Walsh Bay Arts and Cultural Precinct

Re: Modification 7 Request for Information

The Department has requested additional information in response to submissions raised by City of Sydney Council regarding Modification 7 for SSD8671. The Applicant's response is as follows:

DRAWING TITLE:
SHORE SHEDS - GROUND FLOOR
PLAN
SCALES:
1:100 @A0
PHASE:
FOR APPROVAL
DRAWING NO:
A-134
ISSUE:
B

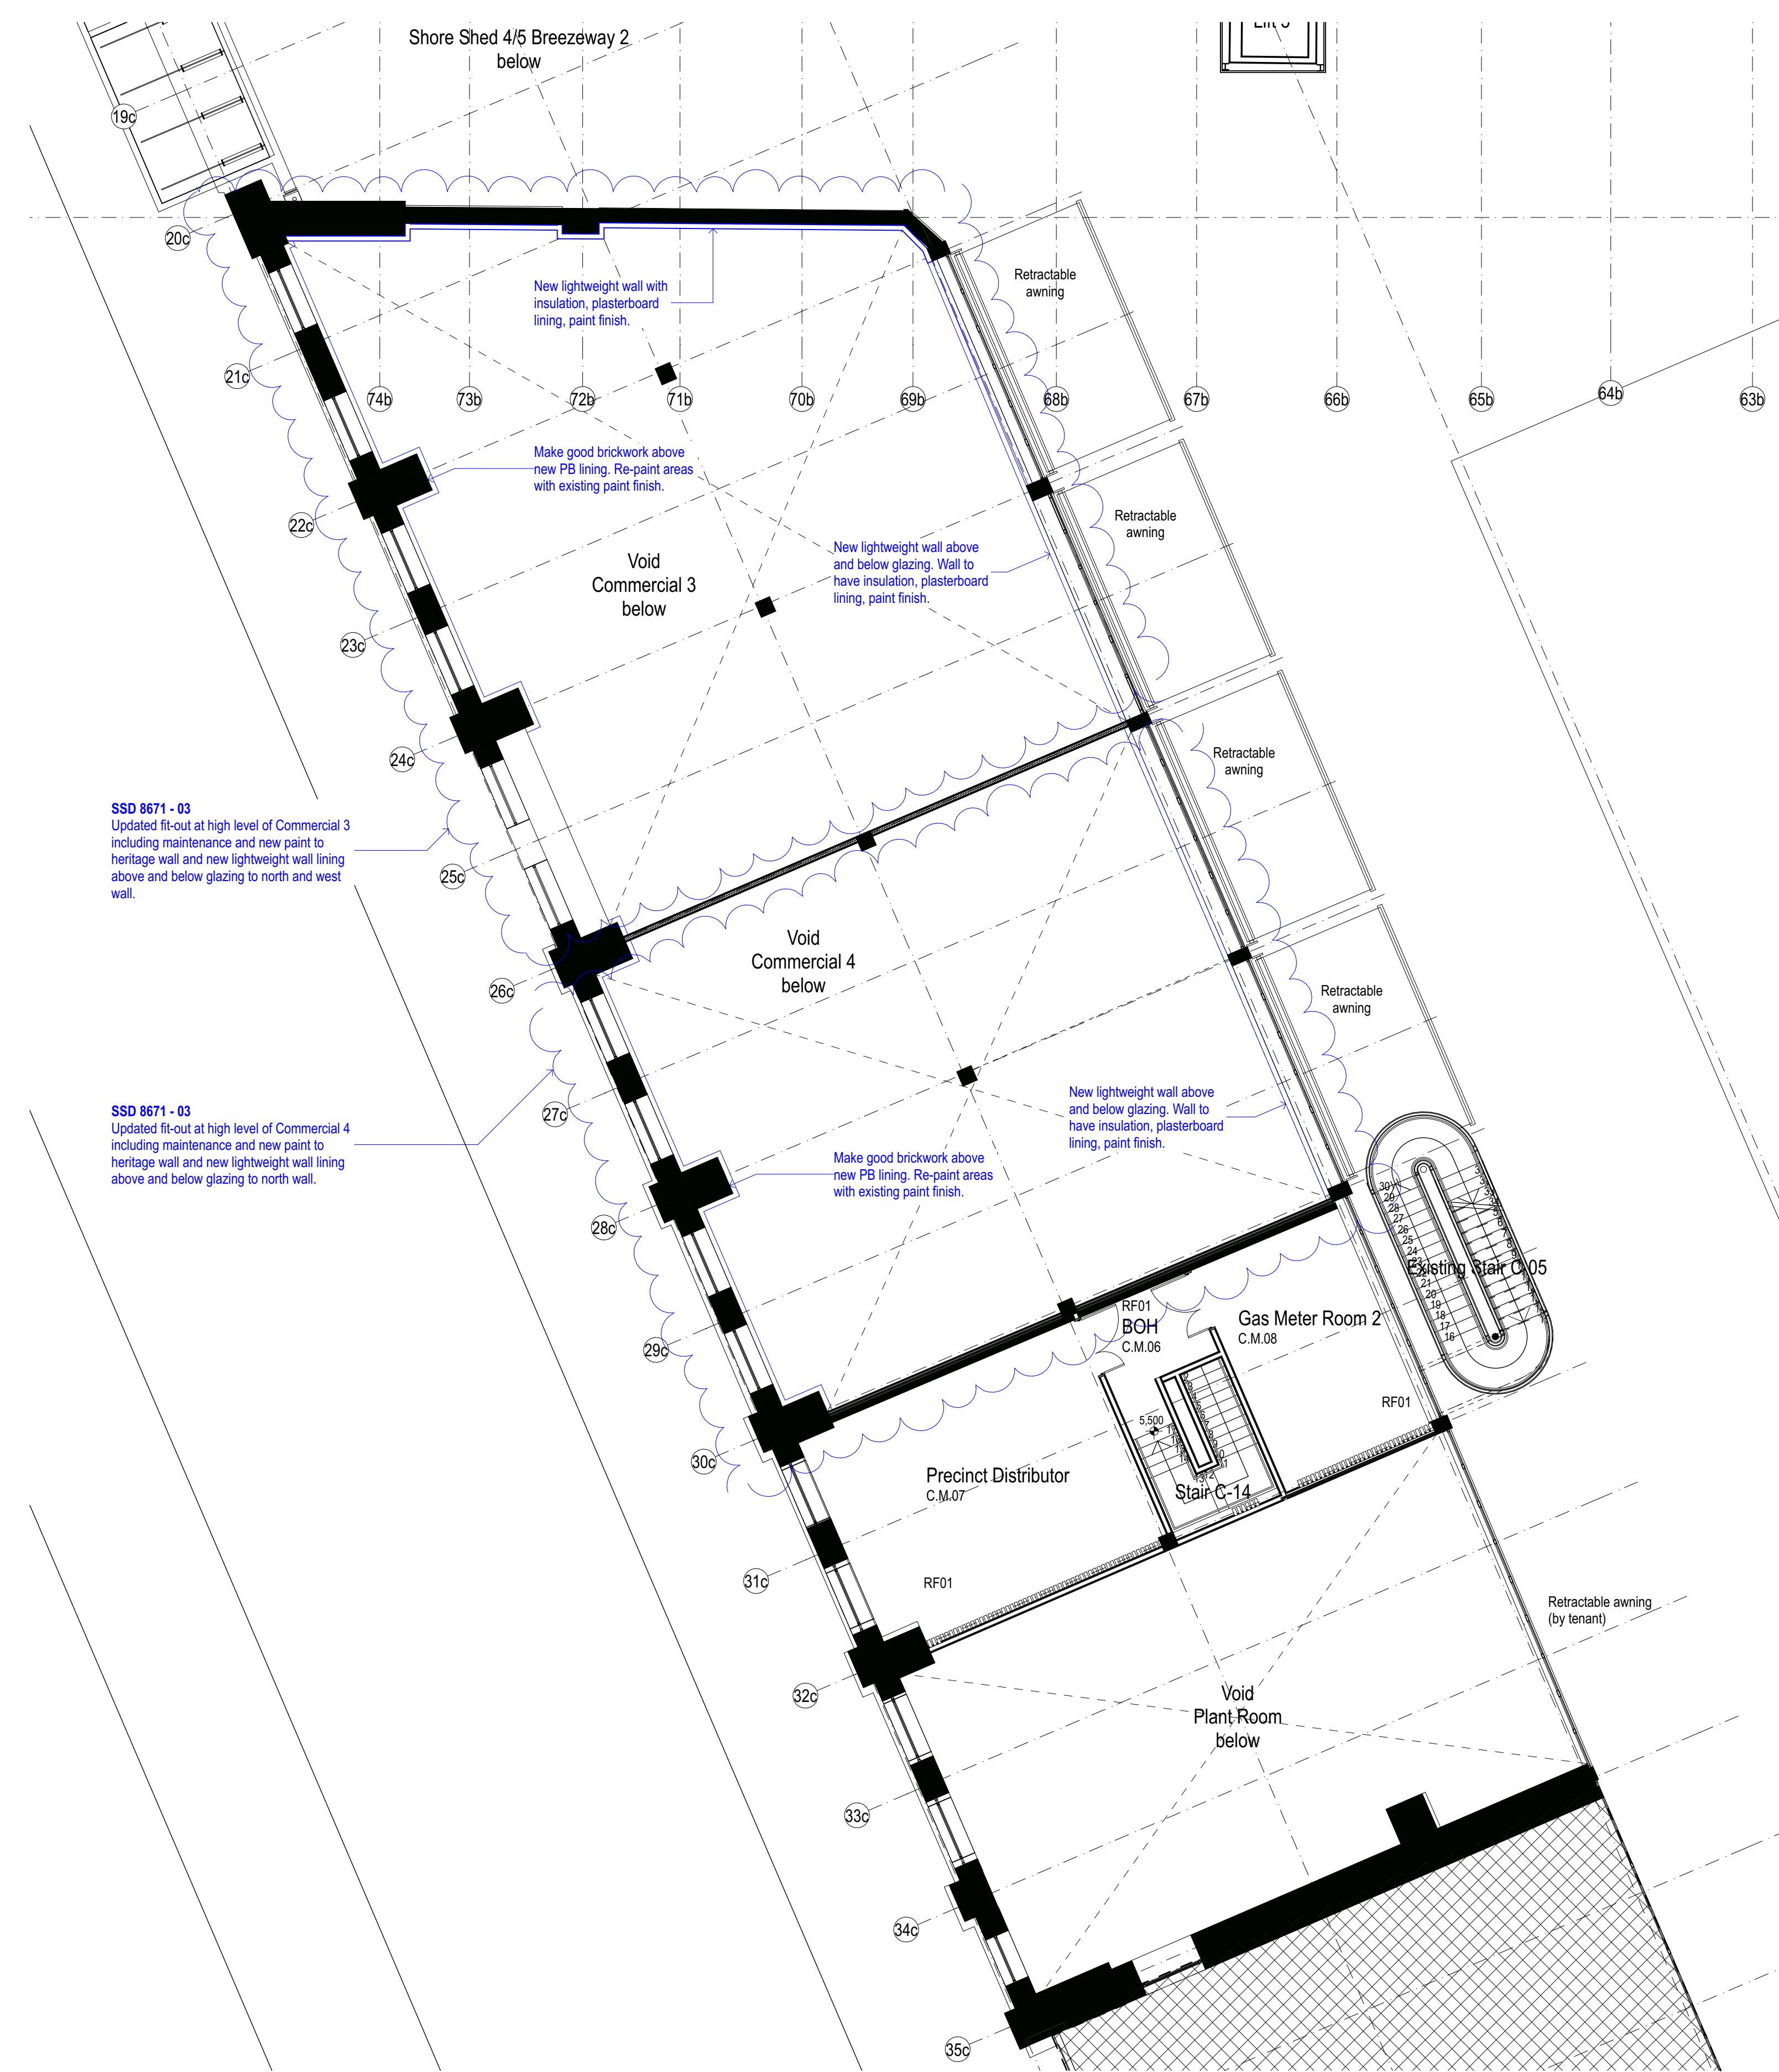
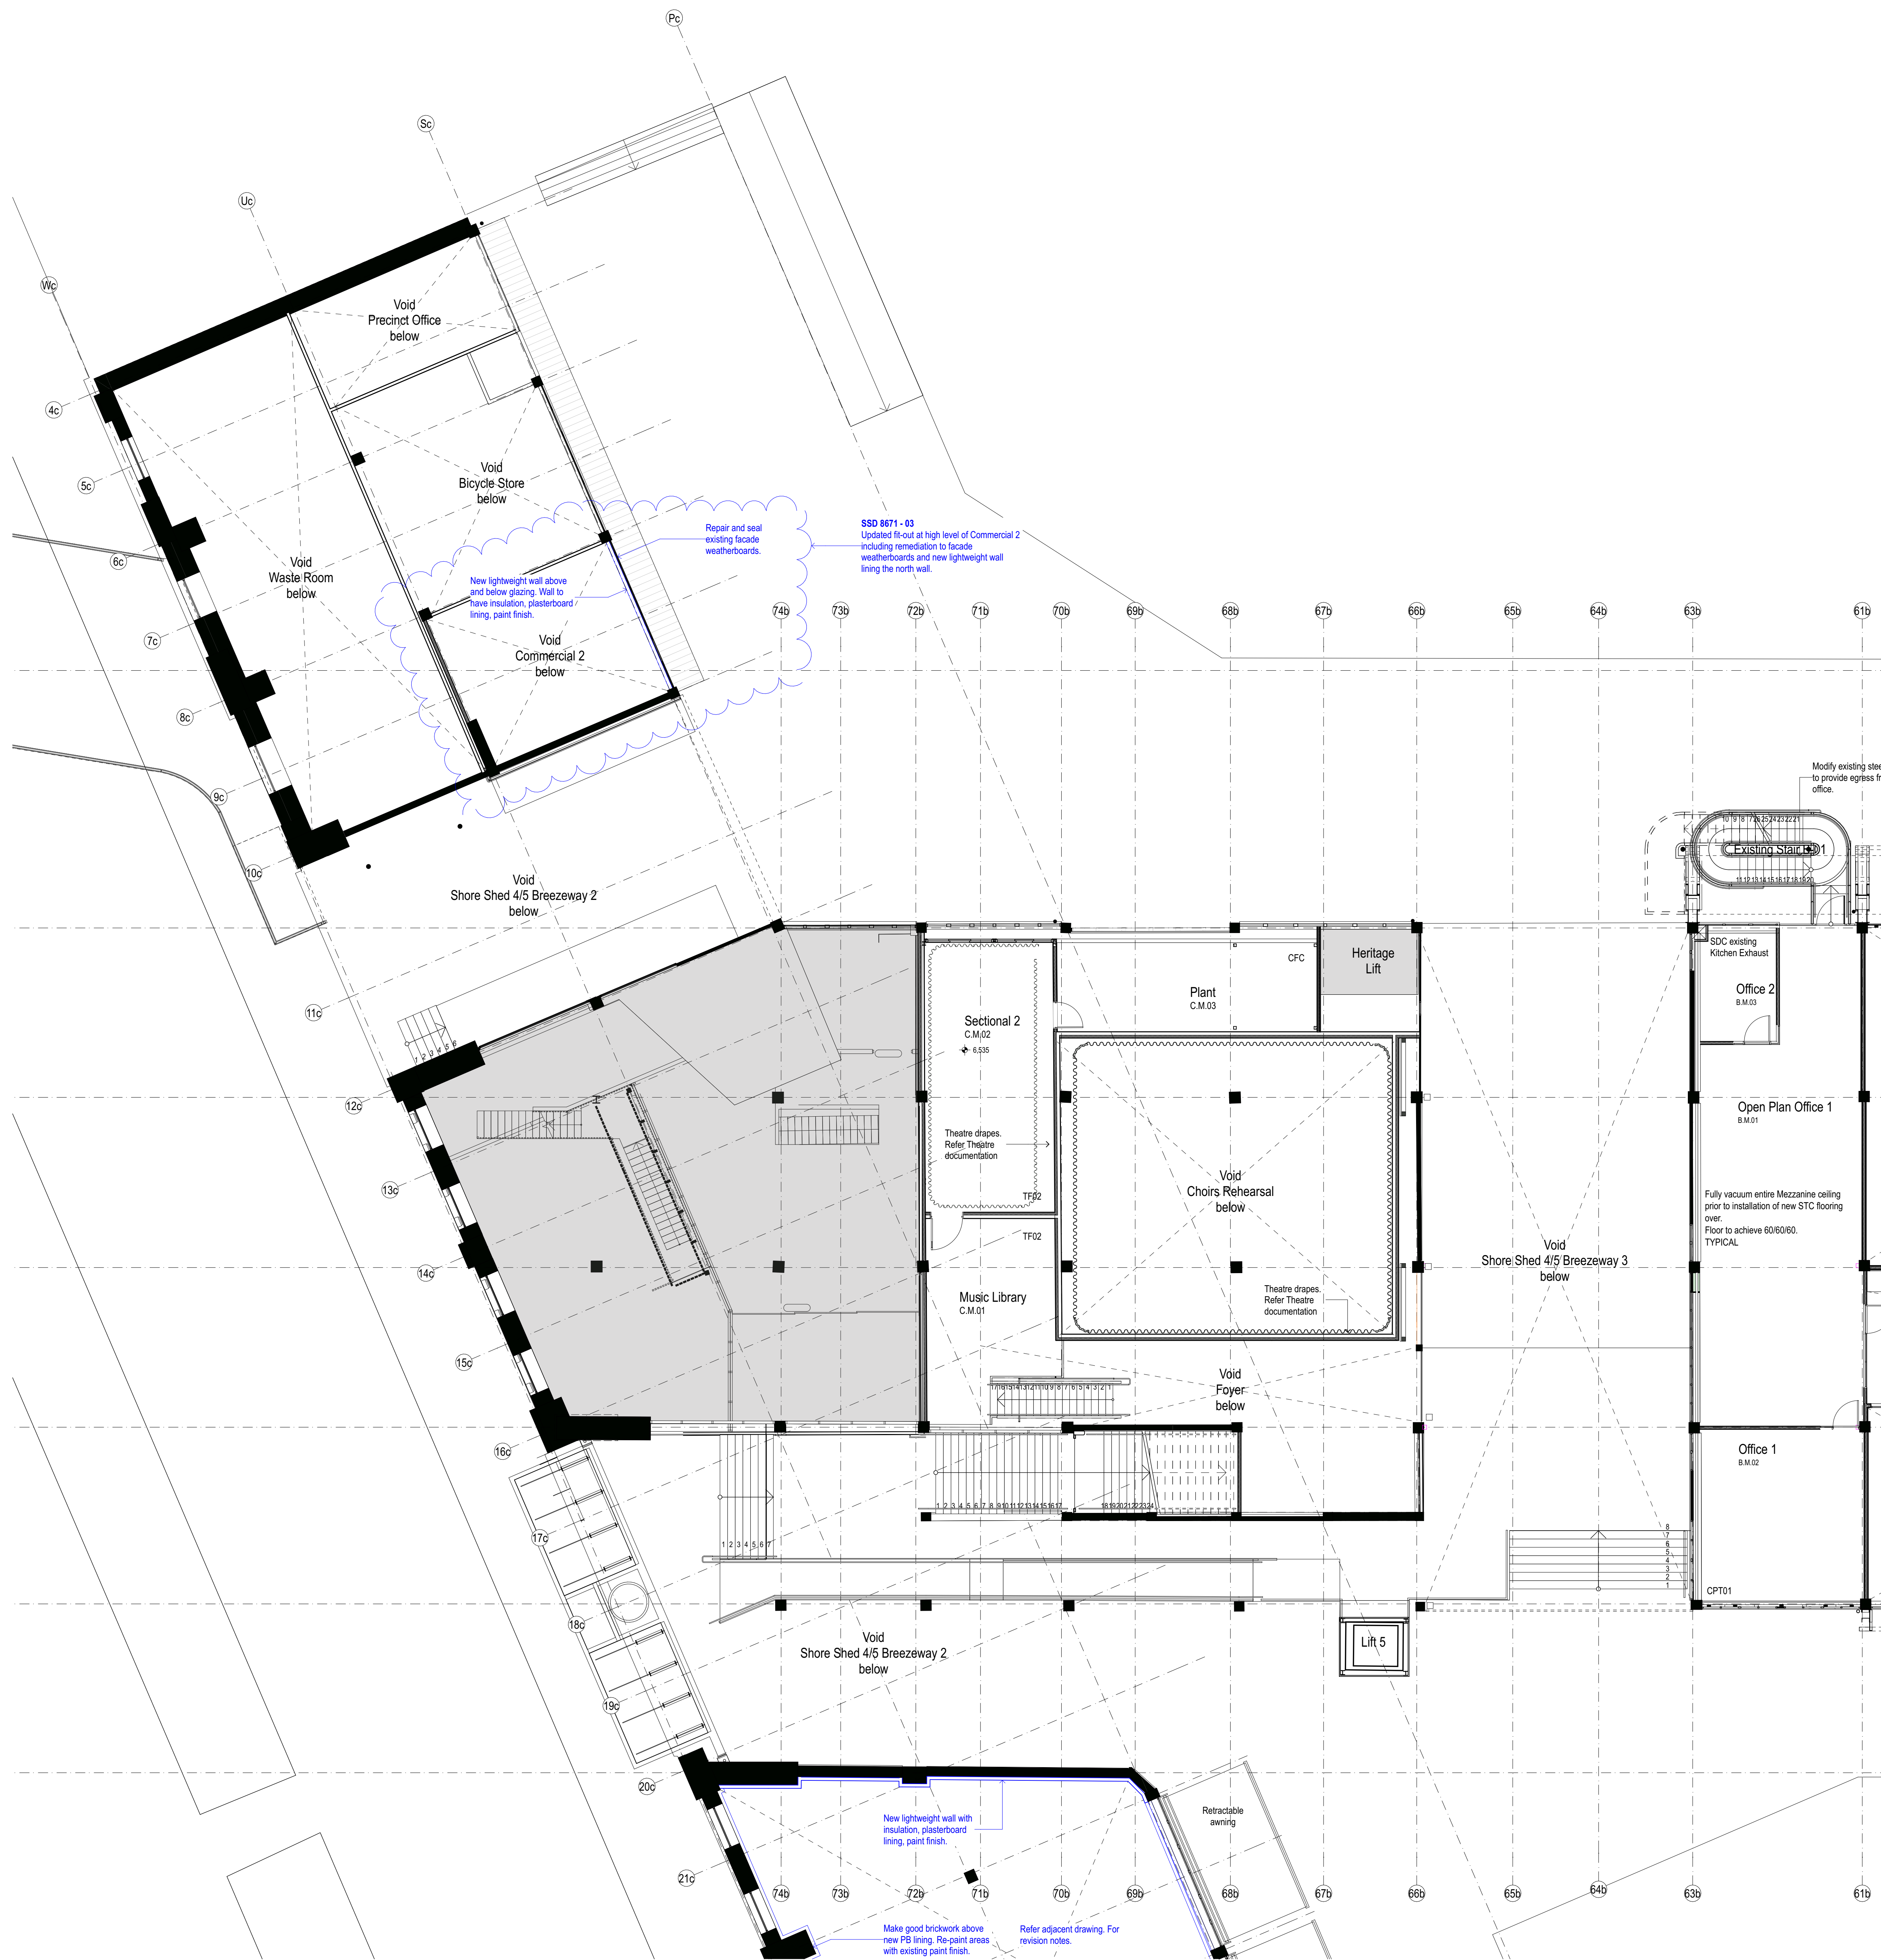
City of Sydney requests the following recommendations contained within the Heritage Impact Statement submitted with the modification are to be included as a condition of consent for additional uses within commercial tenancies 2-4:

- *Sealing and painting of existing weatherboard façade must be carefully carried out. Application of sealant must be neat and consistent. This is to limit further impacts to heritage fabric and maintain a weatherproof and consistent appearance.*
- *Carefully clean brick surface in order to remove dirt, debris and harmful substances. NOTE: No harsh chemicals are to be used.*
- *Where repointing or making good to existing face work are necessary, match sound original brickwork and joints as determined by examination and matching of adjacent areas.*
- *No new chasing to brick wall is permitted.*
- *Any new fixings must be to mortar joints.*
- *New plasterboard lined wall to be set below window sill by approximately 3 bricks to allow interpretation of window sill and max exposure of undamaged brickwork. This will also interpret previous wall tiling to wet area.*

- *New steel framing is to be fixed to existing timber framing with minimal screw fixings at maximum centres. This is to minimise any damage to existing timber fabric, and allow reversibility.*
- *Existing storey posts must be kept exposed. Painting of timber storey posts is not permitted unless previously painted.*
- *Wherever possible, expose timber structural members (beams and bracing) and retain natural finish.*
- *New kitchenettes are to reuse existing service points.*
- *New service points in particular new plumbing to other areas are not permitted.*

Applicant Response: The Applicant raises no objections to such a condition of consent.

Figure 2: proposed eastern façade (Plan A-222, 24/01/22)

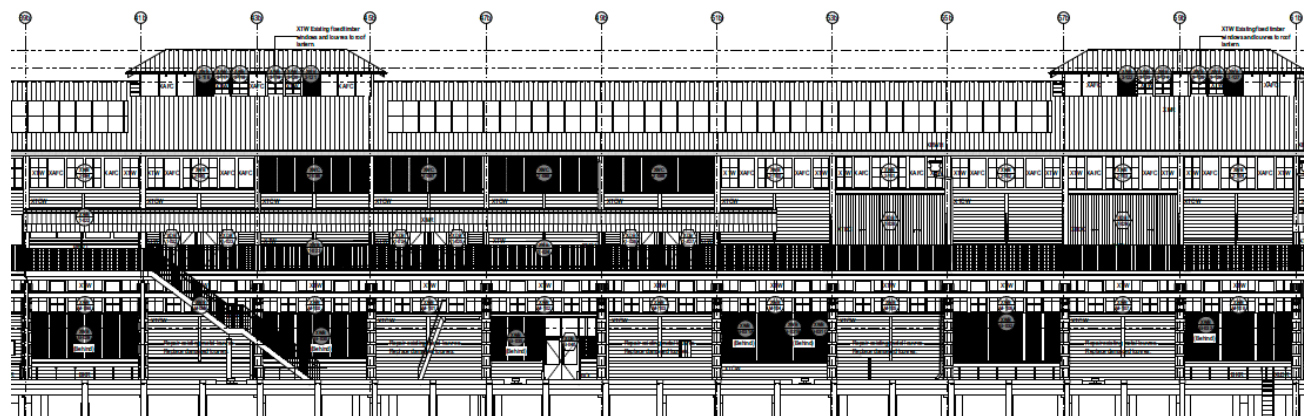
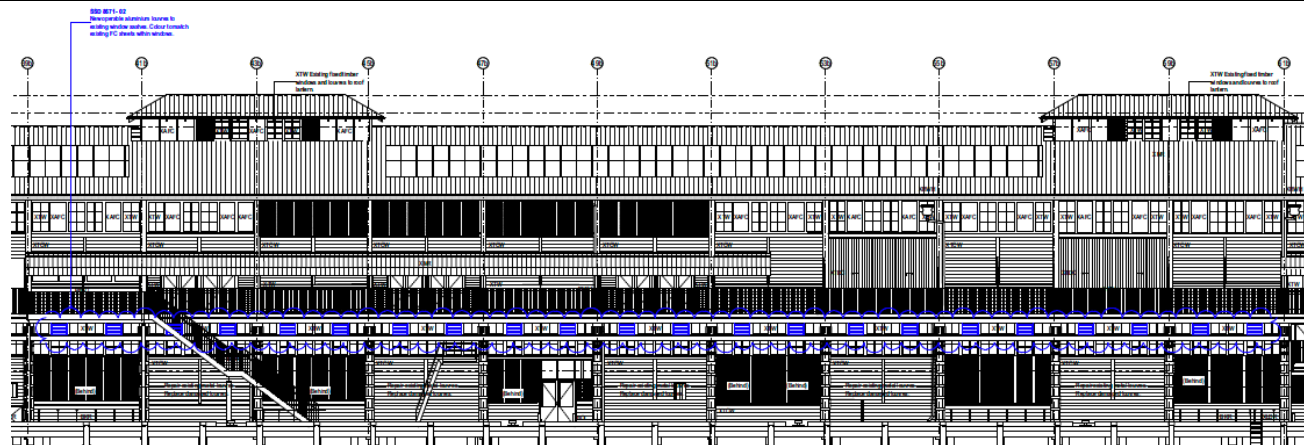
City of Sydney requests the following recommendations contained within the Heritage Impact Statement submitted with the modification are to be included as a condition of consent for installation of louvres:

- *New solid louvres must match colour of existing FC panels.*
- *Removal of existing FC panel must be carried out with care to minimise impact to adjacent heritage fabric.*
- *Installation of new louvres must be carried out with care with no/minimal heritage fabric intervention.*
- *Mechanism for operable louvres must be rationalised and avoid fixing into existing heritage fabric.*
- *If any fixings are required into heritage fabric, they must be minimised to allow reversibility. Heritage Consultant must be notified.*

Applicant Response: The Applicant raises no objections to such a condition of consent.
